FINAL PLAT

UPLAND FLATS BY WATERMARK FILING No. 1
BEING A REPLAT OF TRACT DD OF HANNAH RIDGE AT FEATHERGRASS FILING No. 1
A PORTION OF THE SOUTHEAST QUARTER OF
SECTION 32, TOWNSHIP 13 SOUTH, RANGE 65 WEST OF THE 6TH P.M.
COUNTY OF EL PASO, STATE OF COLORADO

Engineering Review 03/25/2021 5:37:30 PM dsdrice JeffRice@elpasoco.com (719) 520-7877 EPC Planning & Community Development Department

PCD File No. SF-21-012

FINAL PLAT
UPLAND FLATS BY WATERMARK FILING No. 1
 BEING A REPLAT OF TRACT DD OF HANNAH RIDGE AT FEATHERGRASS FILING No. 1
 A PORTION OF THE SOUTHEAST QUARTER OF
 SECTION 32, TOWNSHIP 13 SOUTH, RANGE 65 WEST OF THE 6TH P.M.
 COUNTY OF EL PASO, STATE OF COLORADO
AS REPLATTED

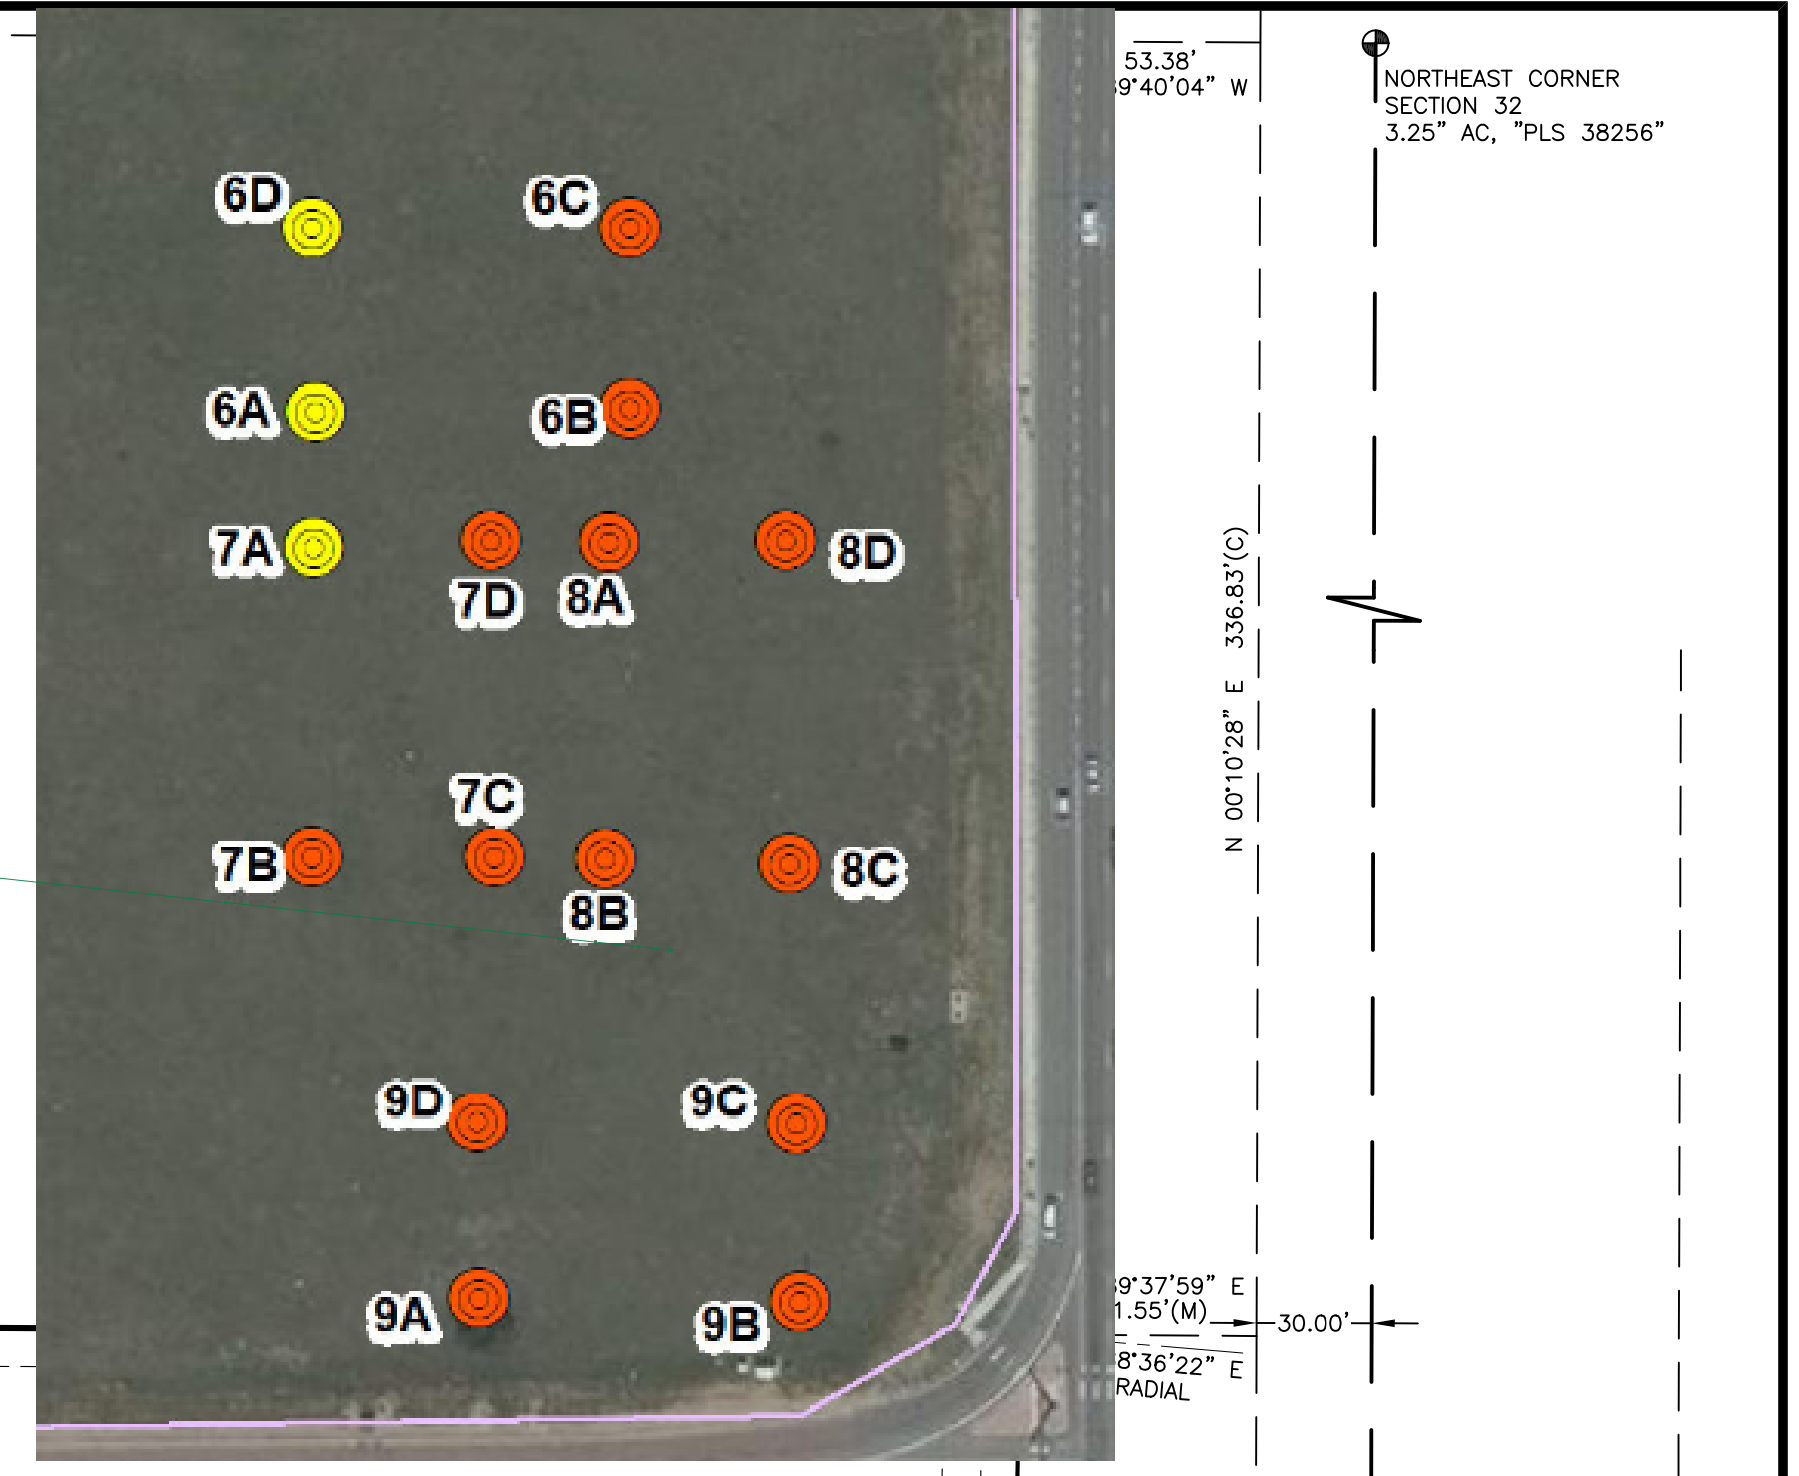
Noise mitigation is required...Depict setback, or wall, and provide corresponding notes... Add to FAE

Title commitment B2 #10 show or note that this cannot be located :
 RIGHT OF WAY EASEMENT AS GRANTED TO COLORADO INTERSTATE GAS CO. IN INSTRUMENT RECORDED SEPTEMBER 26, 1934, IN BOOK 908 AT PAGE 91.

The adj subdivision has provided the 7.5-foot Public improvement easement along Constitution verify with Engineering this is necessary or not with this plat.

Show the 20' ROW dedication per TIS.

25- feet of fall through site. Grading plan ? retaining walls? We need this info w plat to guarantee improvements w SIA. There is a pond shown with no GEC .

label & depict CSU's two easements and identify if they are to be vacated by this plat instrument, provide documentation that the easement holder is agreeable to the vacation.

100-foot setbacks are suggested for mitigation in Noise study constitution

150-foot setbacks are suggested for mitigation in Noise study from Marksheffel

Easement at Rec. No. 215010318?

LOT 8  
AKERS SUBDIVISION No. 1  
BOOK H-2 PAGE 48  
KINGSTON GROUP LLC  
26775 AKERS DRIVE  
TSN 5332002014

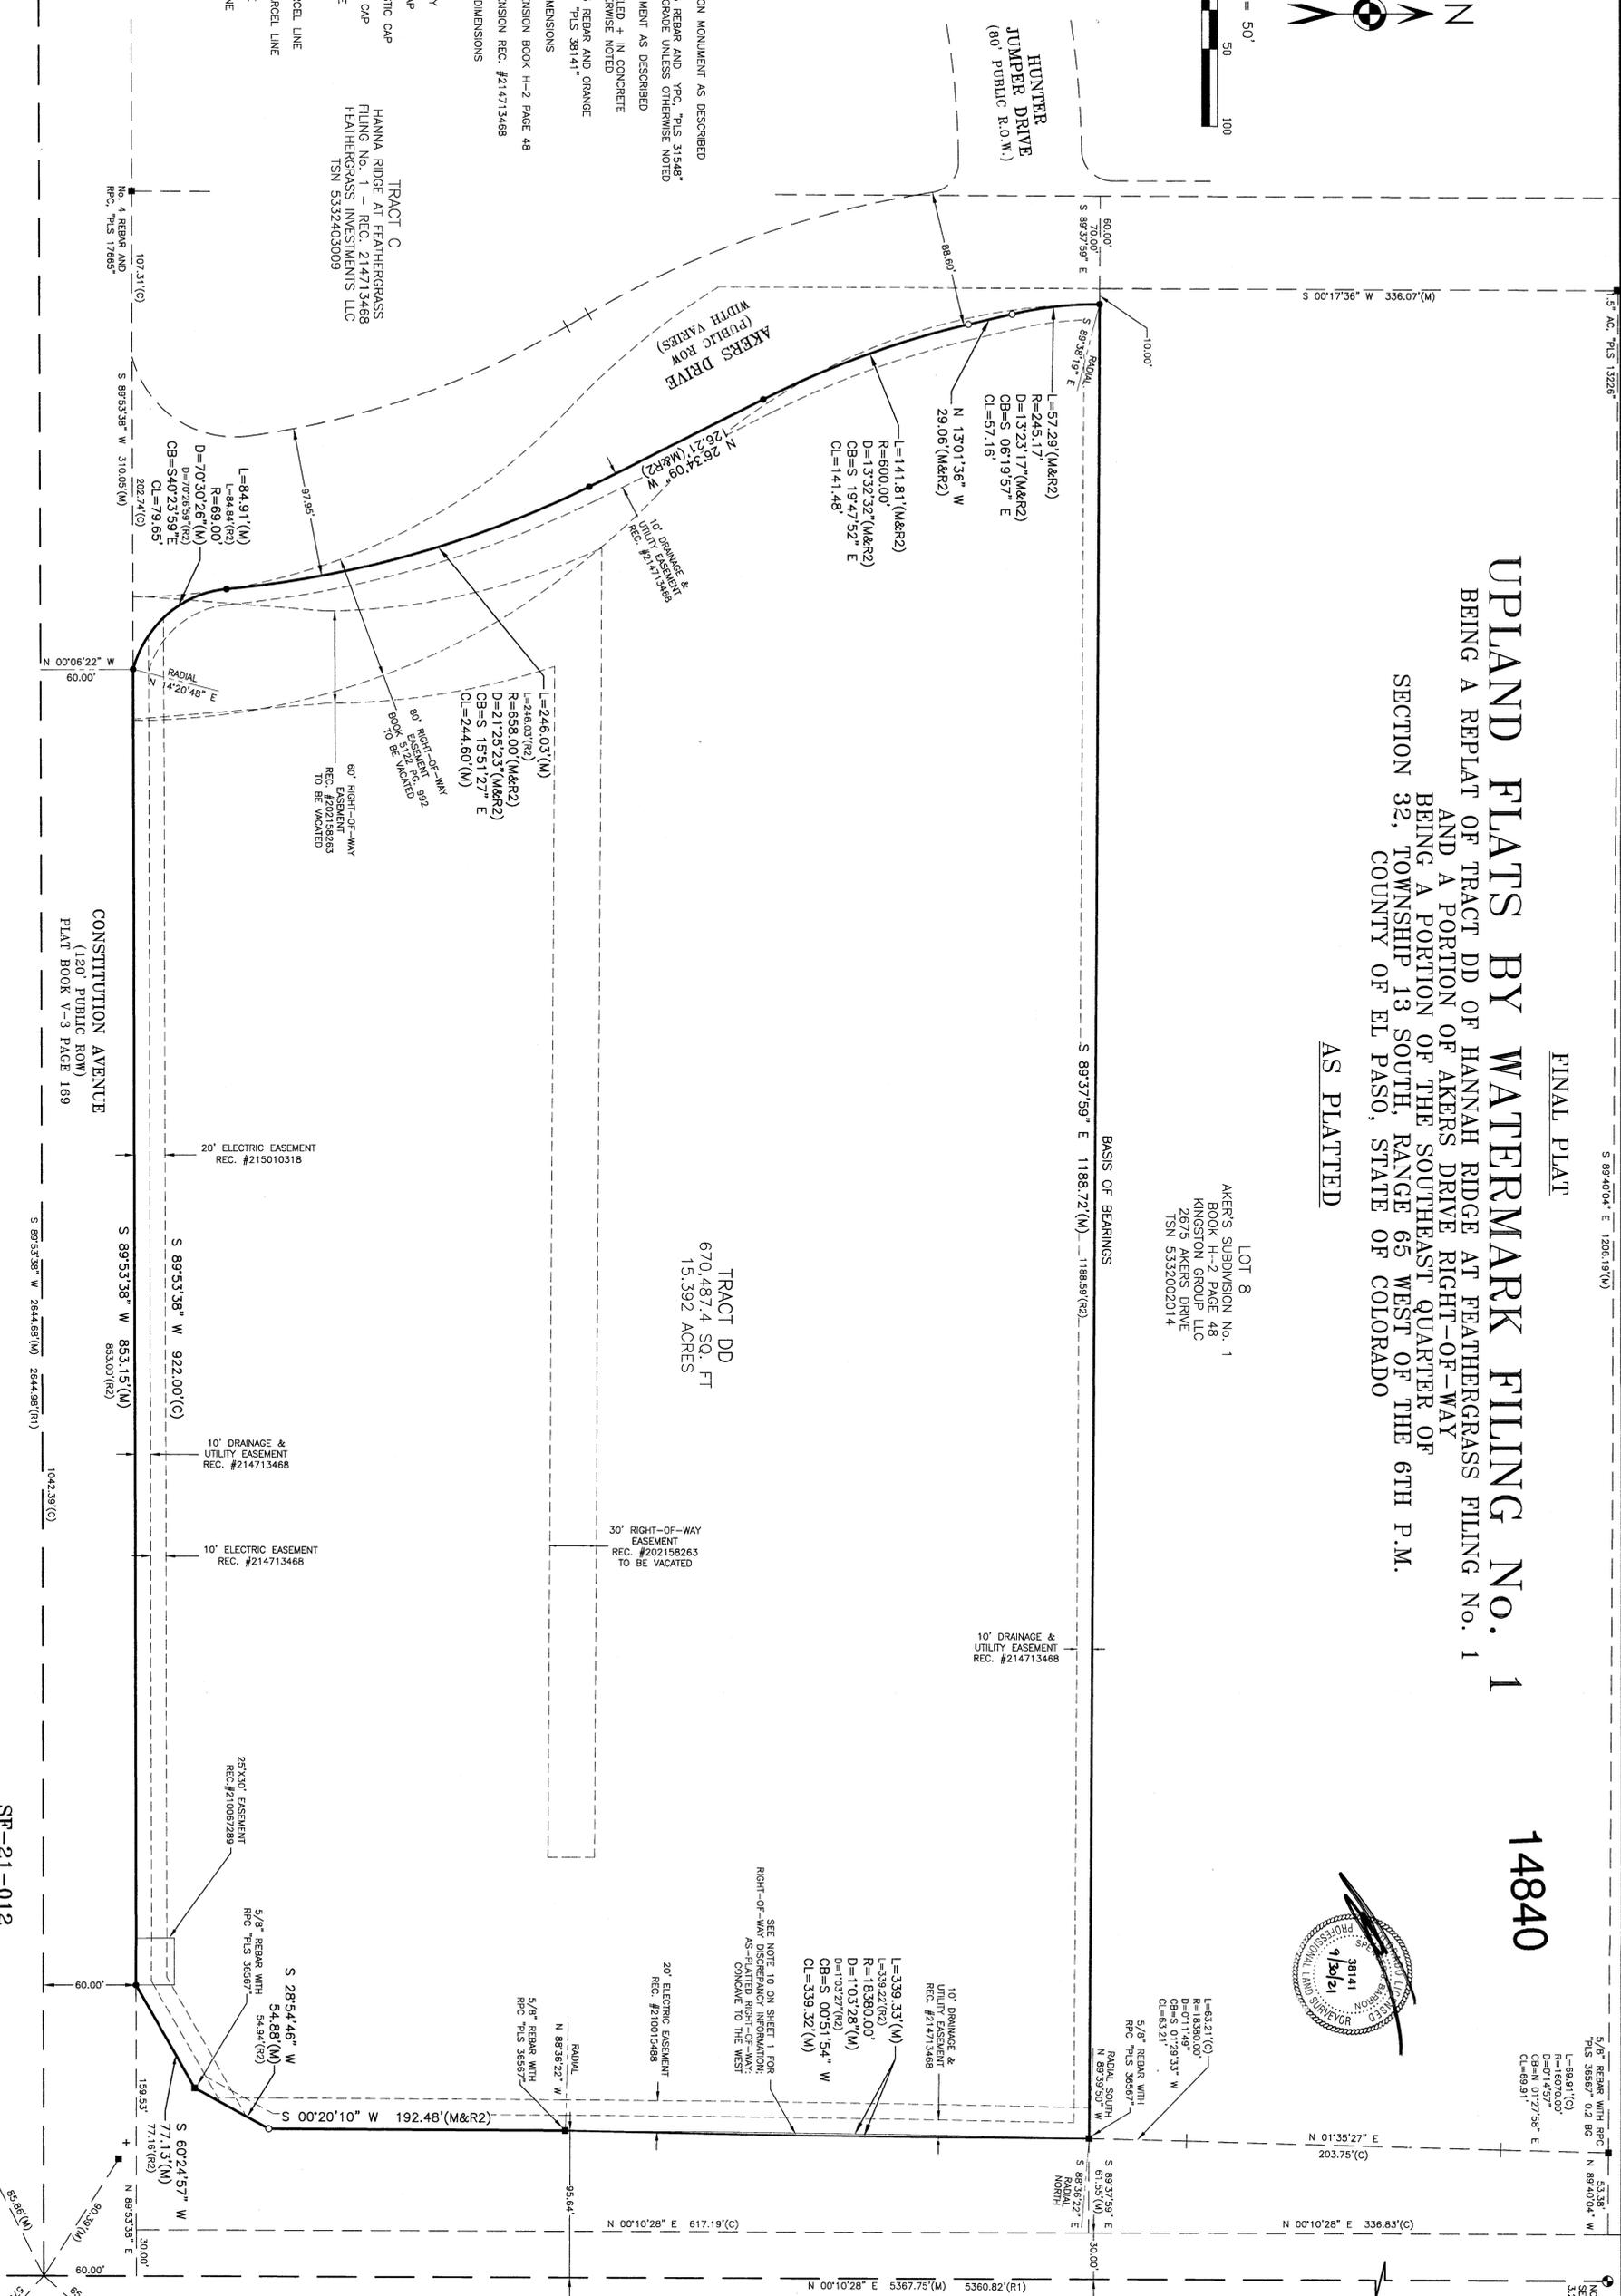
label & depict CSU's
 two easements and
 identify if they are to
 be vacated by this
 plat instrument,
 provide
 documentation that
 the easement holder
 is agreeable to the
 vacation.

to be vacated?
 Please state
